WEST SUSSEX COUNTY COUNCIL CONSULTATION

TO:	Arun District Council FAO: Simon Davis
FROM:	WSCC - Highways Authority
DATE:	12 March 2021
LOCATION:	Land To North And South Of Summer Lane Pagham PO21 4NG
SUBJECT:	P/29/21/DOC Approval of details reserved by condition imposed under ref P/58/15/OUT relating to Condition No 14 - highway works.
DATE OF SITE VISIT:	n/a
RECOMMENDATION:	No Objection
S106 CONTRIBUTION TOTAL:	n/a

PROJECT SUMMER LANE, PAGHAM				CLIENT HANBURY PROPERTIES LTD	
DRAWING TITLE SECTION 278 HIGHWAY WORKS				vectos. 4th Floor Oxford Place, 61 Oxford Street, Manchester, M1 6EQ	
DRAWN AM	CHECKED PW	DATE 16.02.2021	SCALE AT A1 1:200	DRAWING NUMBER VD16396-ID-SK-0005	REVISION A

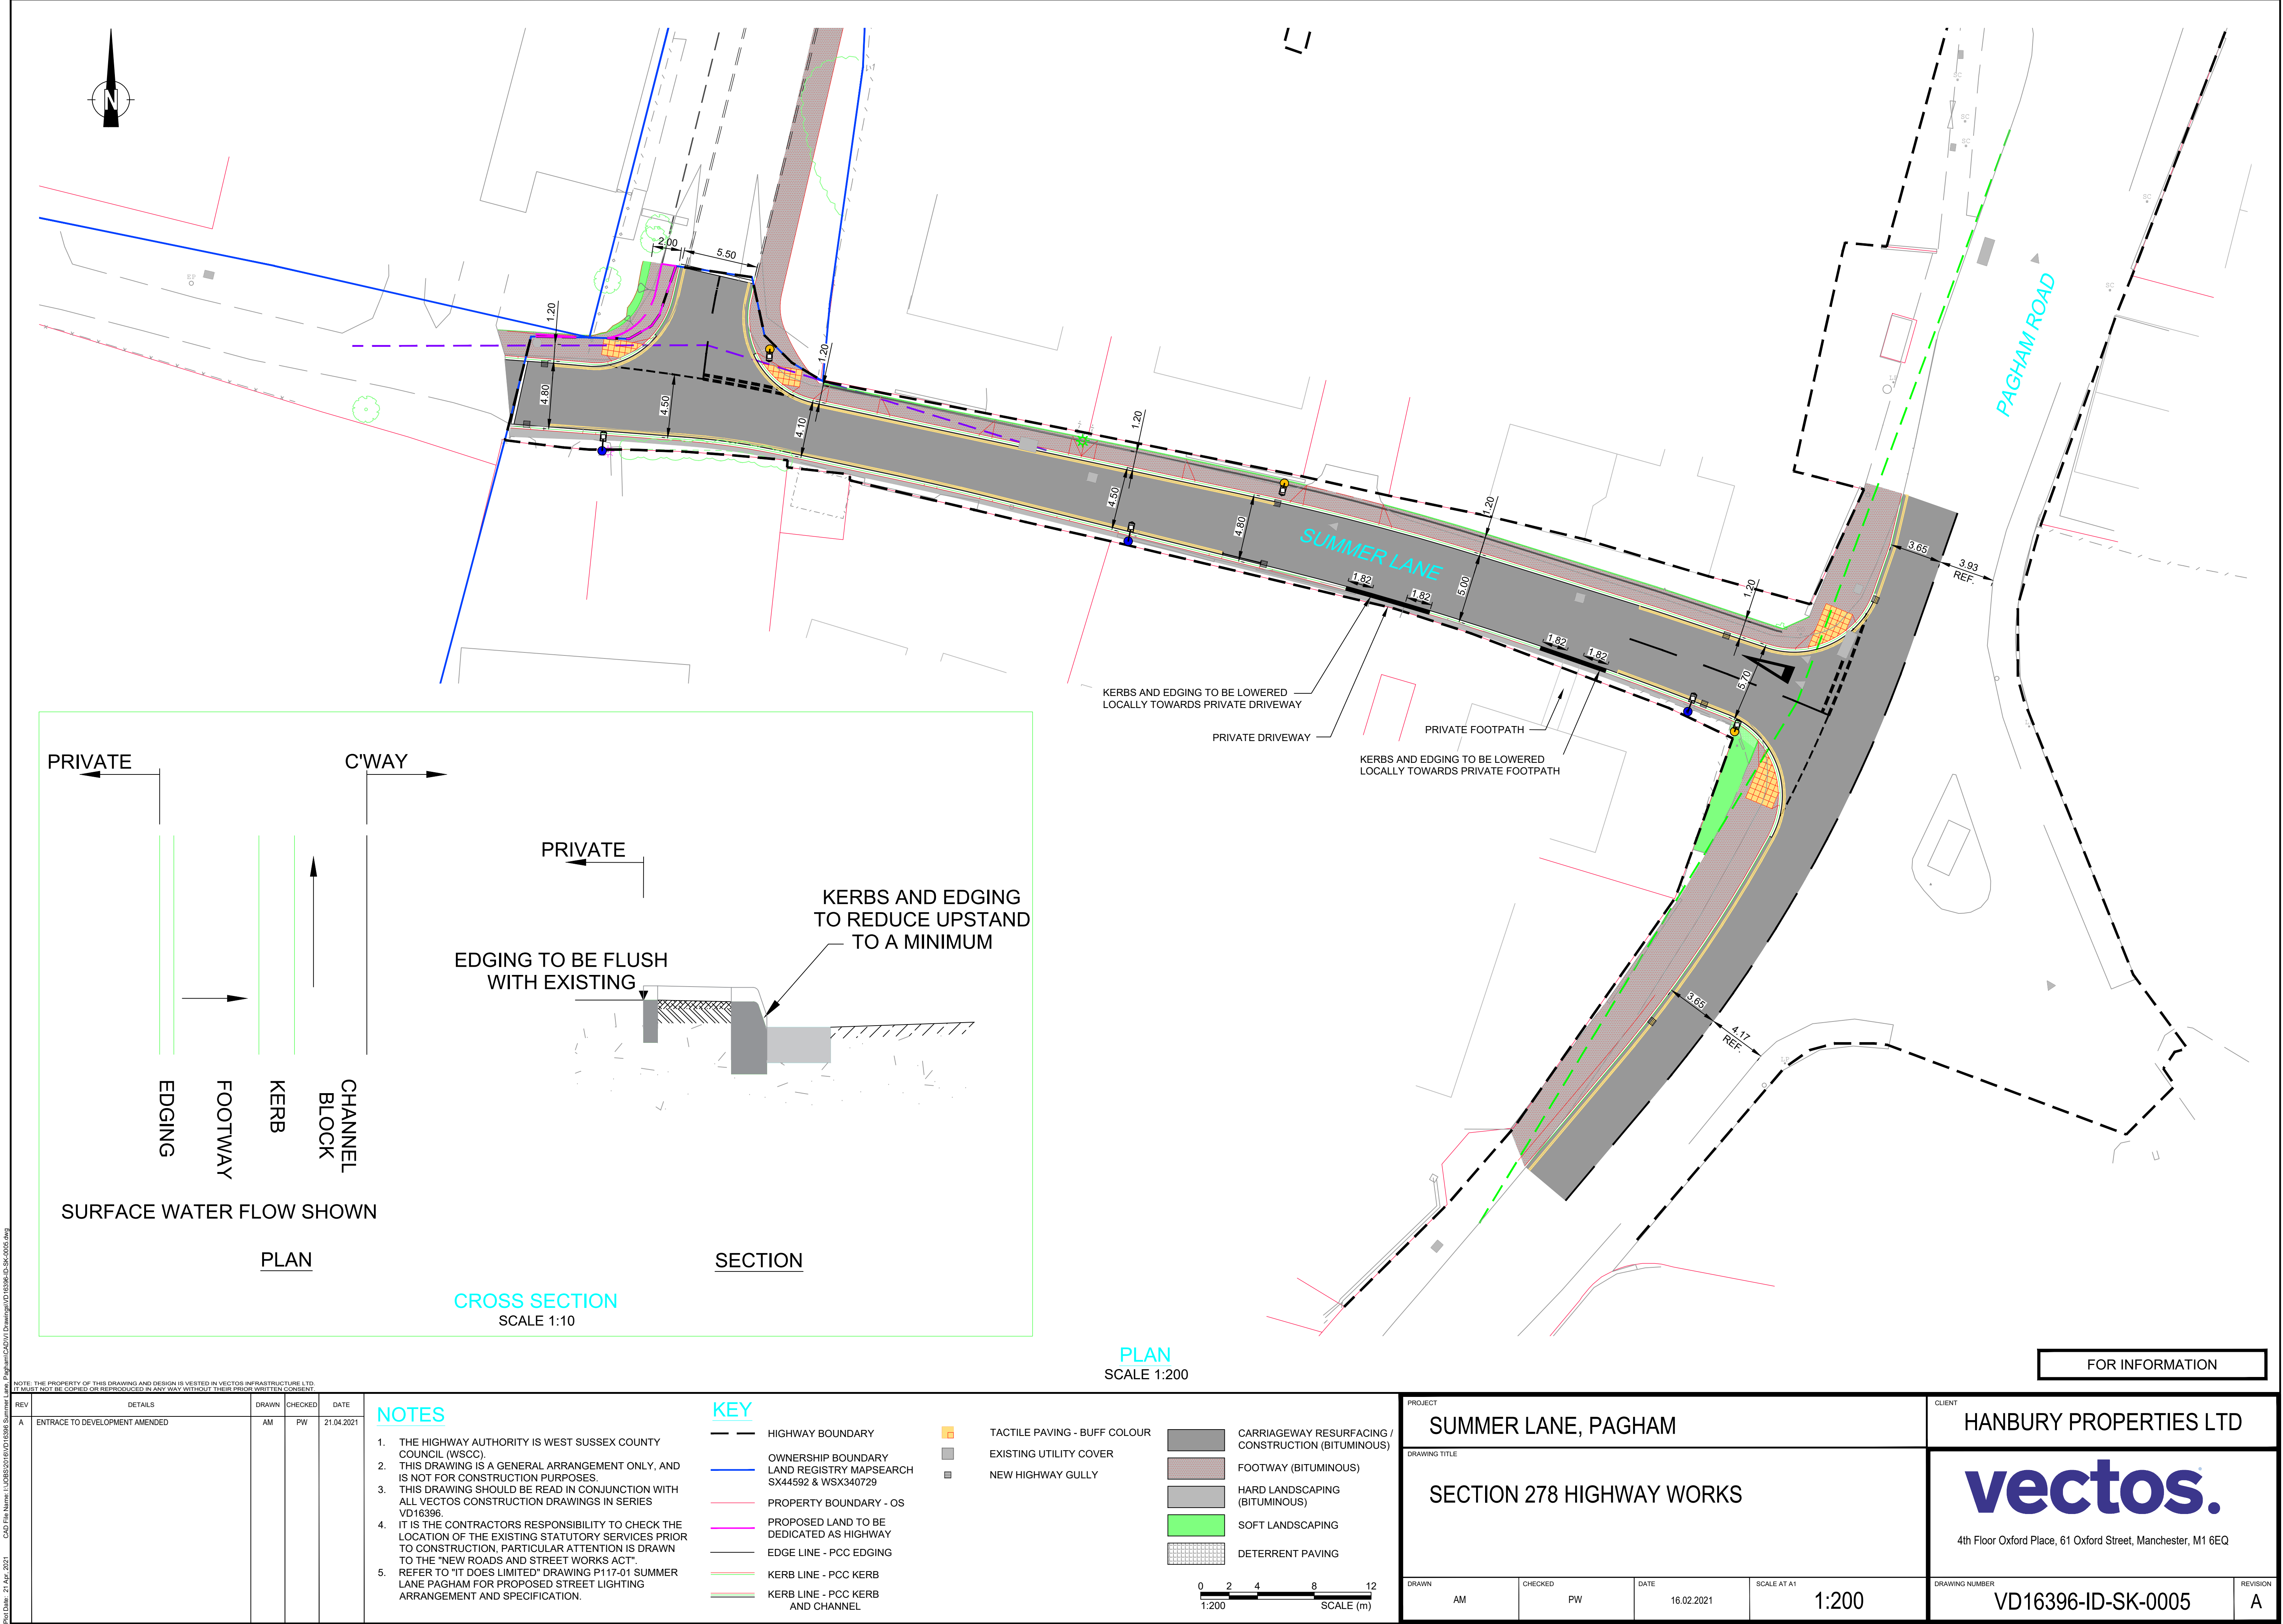
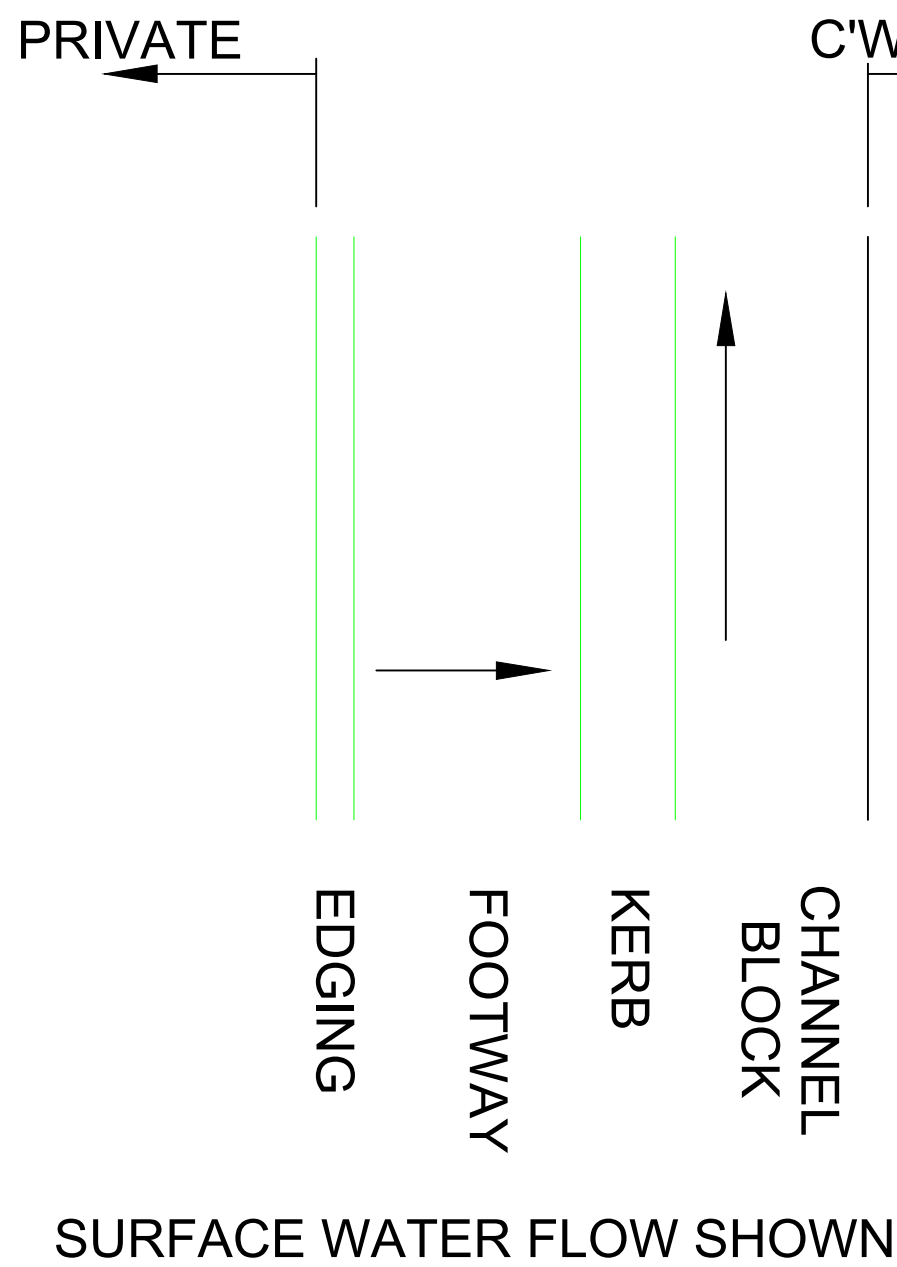
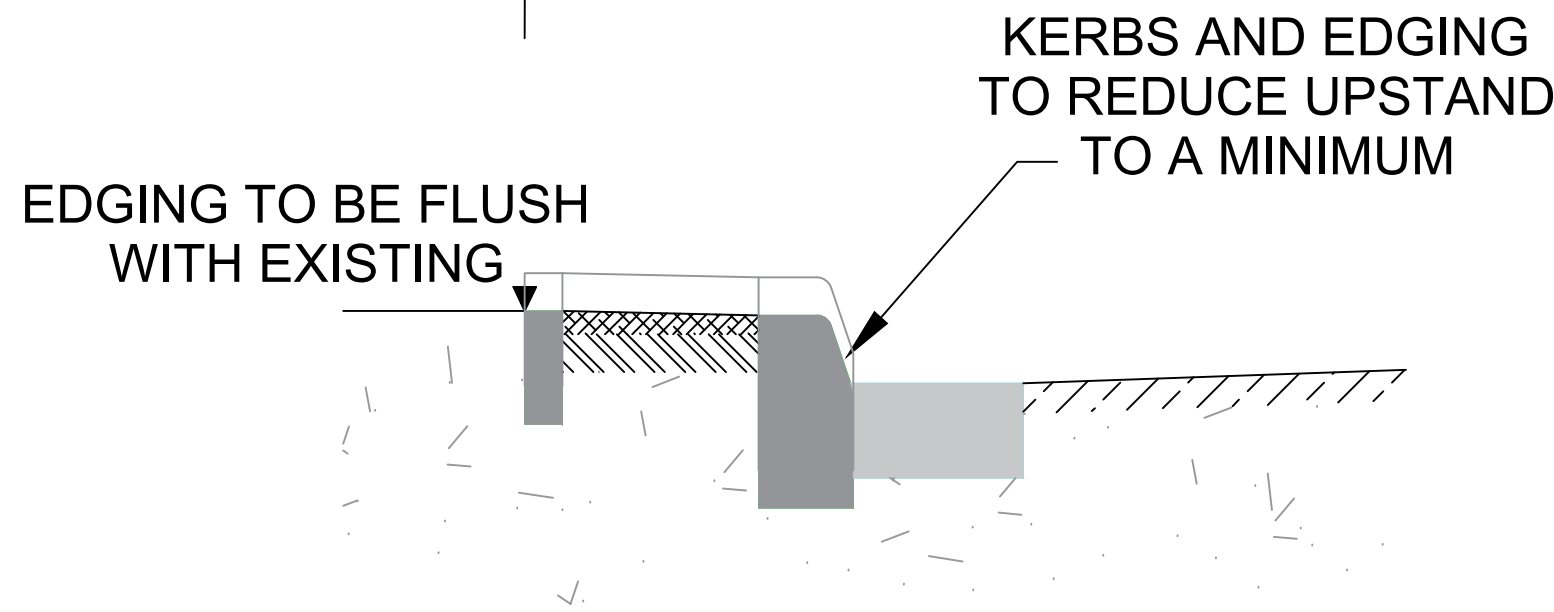
The majority of the works shown on the drawing submitted to satisfy this condition reflects the indicative arrangements shown on the drawing referenced in the condition. The only aspect that is understood to vary is the footway width on the northern side of Summer Lane. The indicative arrangement includes a 1.5 metre wide footway on the northern side. Through the detailed design, it has become apparent that a number of private driveways would need to be altered to tie in with level of the new footway. The developer has been unable to obtain the necessary consents from the landowners to make the alterations. As a result, the footway width is having to be reduced to enable construction and overcome the tie in/level issue.

The reduction in width is undesirable but in the circumstances unavoidable. In light of the site constraints, the details are considered acceptable. Condition 14 can be discharged.
